CITY OF ALBUQUERQUE

RE: **Rohan Subdivision**
Lots 1P1 – 4P1
Requested for Pad Cert – Not Accepted
Engineers Stamp Date 6/29/15 (C19D042A)
Certification dated: 6-8-18

LOTS 1 THRU 4, ROHAN SUBDIVISION GRADING AND DRAINAGE PLAN

**LOTS 1 THRU 4, ROHAN SUBDIVISION
GRADING AND DRAINAGE PLAN**

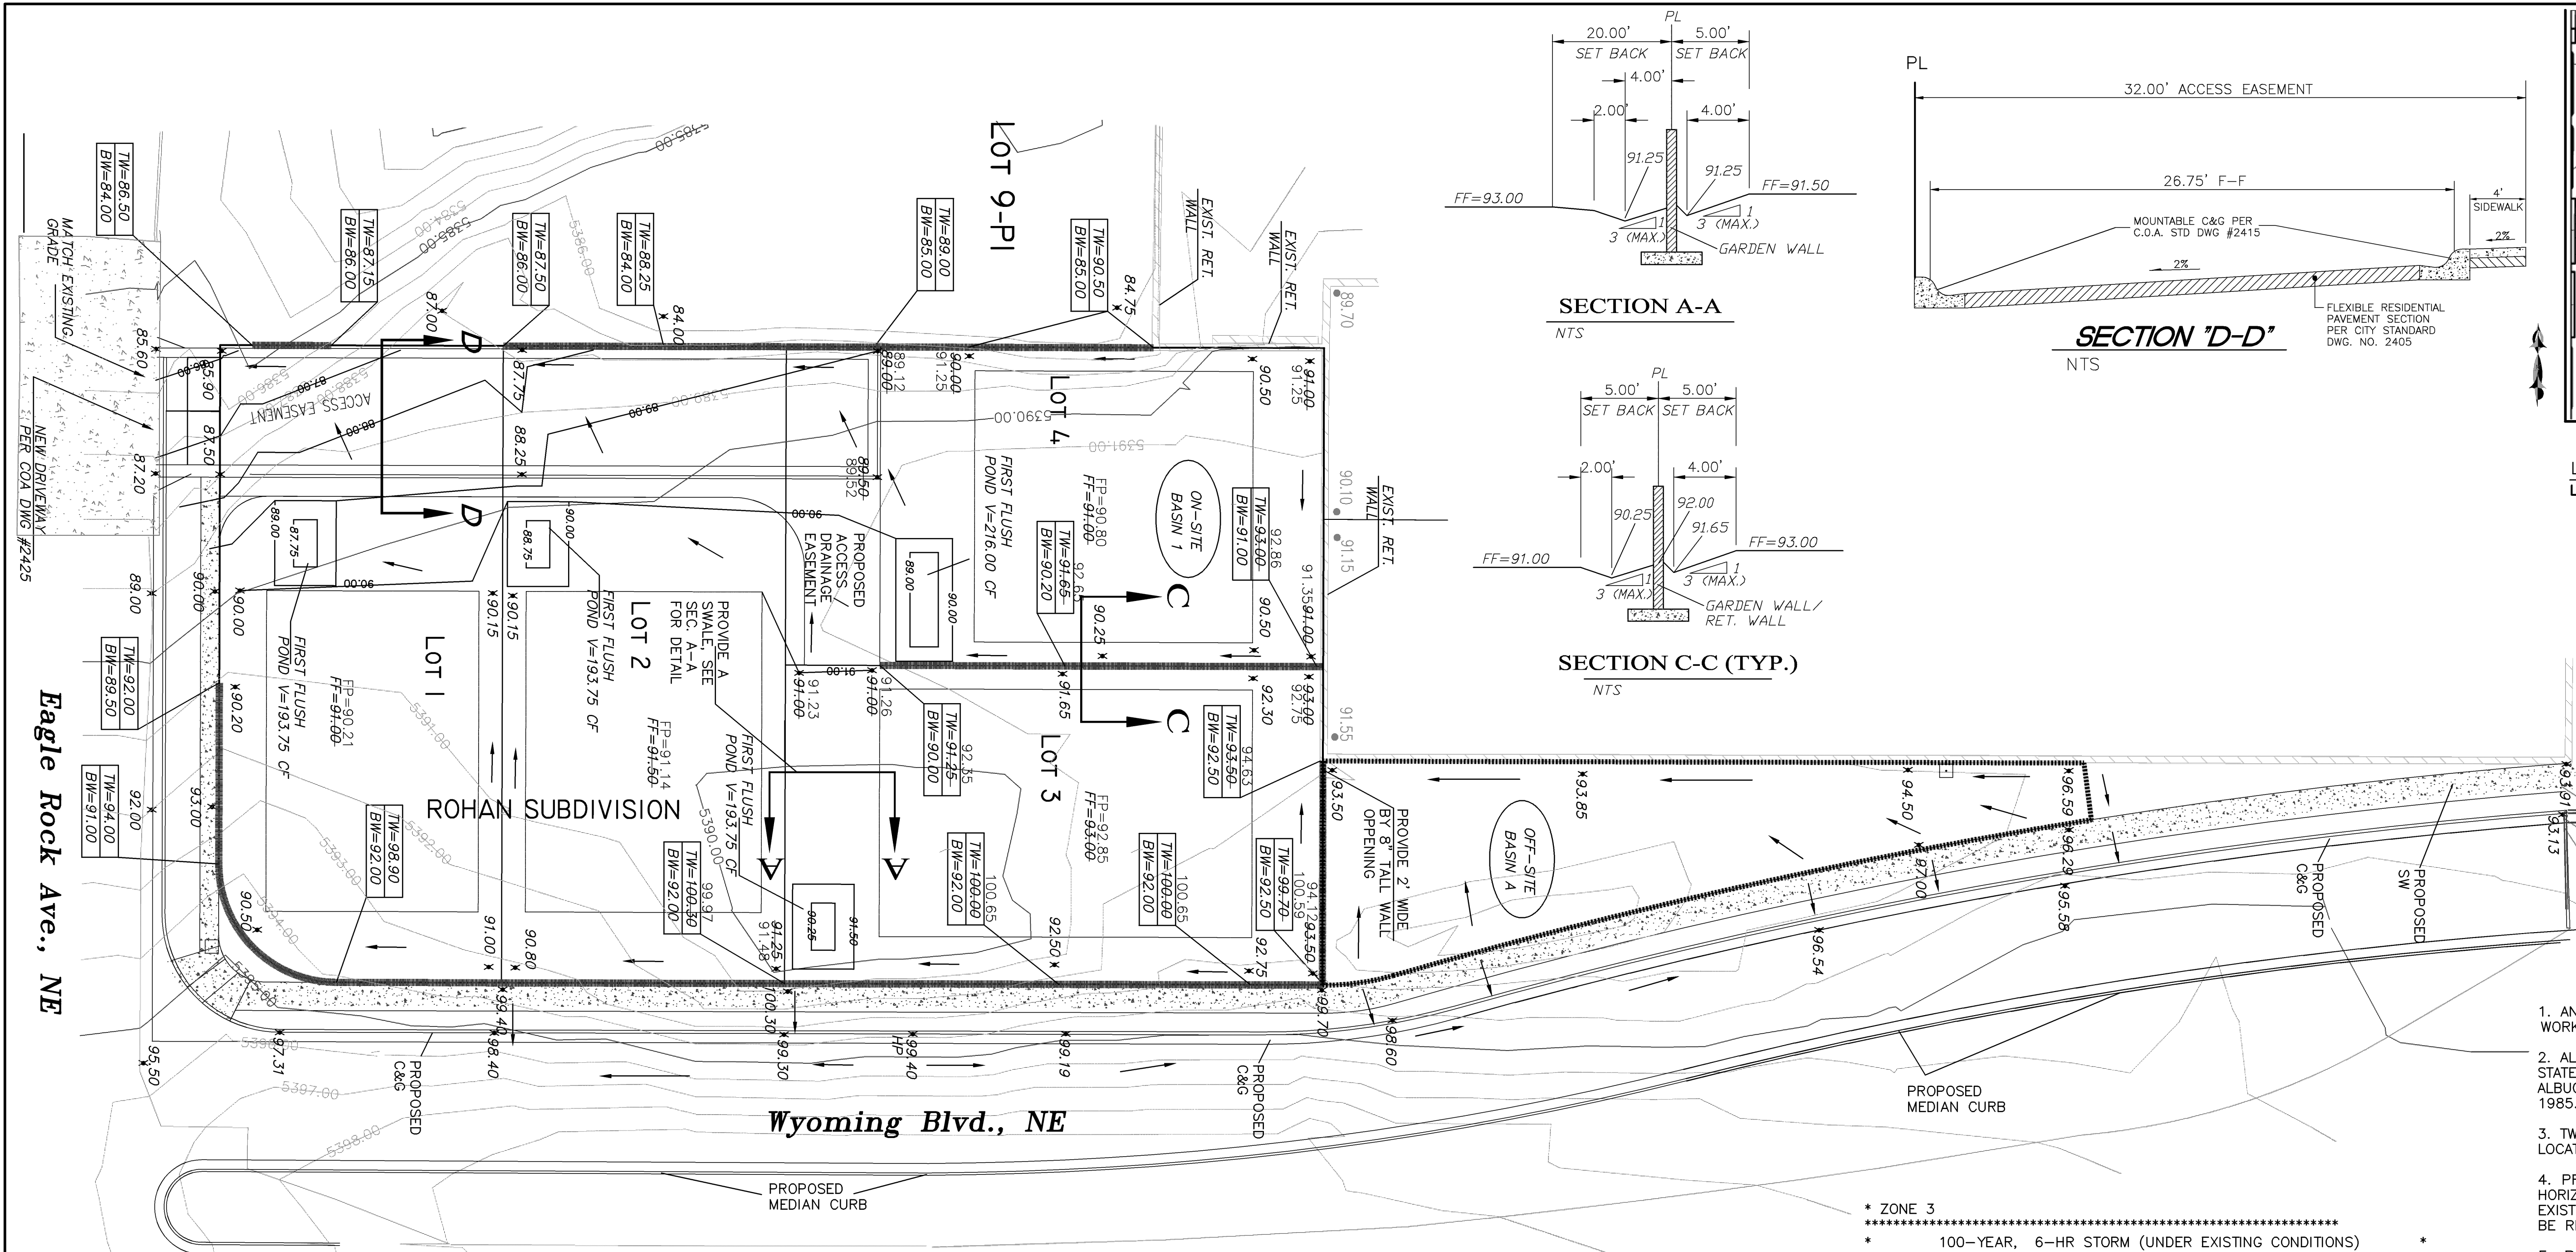
- The private road must be paved.
- The retaining wall between the 2 lots must be completed.
- The 2' wide by 8" wall opening must be completed.
